## PRELODGE MENT PANEL ADVICE

**PROPERTY:** Lot 117 Lachlan's Line (6 Halifax Street, Macquarie Park).

**PRELODGE MENT No:** PRL NO 2023/6 – Supplementary Advice

**DEVELOPMENT:** Proposed Affordable housing development. 9,887sqm of GFA including 13 storeys 38 car parking spaces and total 135 units

I
3-00 TYPICAL SECTION - MEWS ROAD

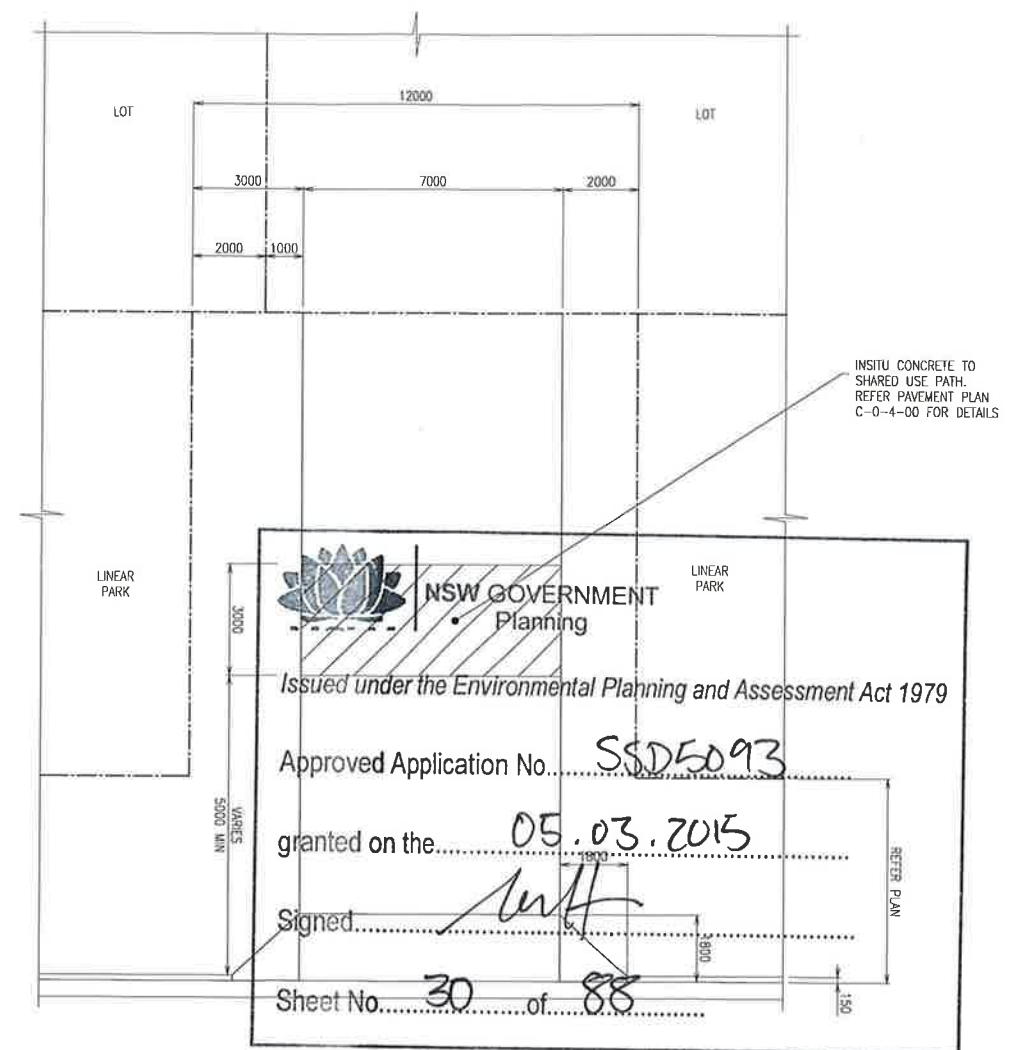
The LLUDG requires a Mews Road Width of 17.5m for the site, whilst the Applicant has proposed a 13.5m Mews Road. This is inconsistent with the LLUDG. The Applicant is advised to thoroughly consider the objectives of control 3.2 *Circulation Networks* and 4.2 *Construction of Mews Road and Vehicular Access* of the LLUDG should they wish to investigate a Mews Road width reduction.

The applicant justifies reduction in the width of Mews Road through removal of required footpaths under the LLUDG. If the footpaths are removed, it is unclear how the pedestrian connection, permeability and access would be achieved under the proposed Mews Road design. The information provided with the supplementary package does not sufficiently demonstrate how the reduction of Mews Road width, would sufficiently support pedestrian access and permeability. Should the Applicant explore a reduction of a Mews Road width, they should ensure appropriate access and permeability is achieved in the reduced Mews Road Width. These details were not provided.

The reduction of the Mews Road width should not comprise the Mews Road ability to deliver Street Planting on the Mews Road as required by *Control 3.4 Landscape and Deep Soil* of the LLUDG. Should the applicant explore a reduction in the width of Mews Road, they should ensure there is sufficient widths available for street trees on the Mews Road, with appropriate soil depths to enable tree growth.
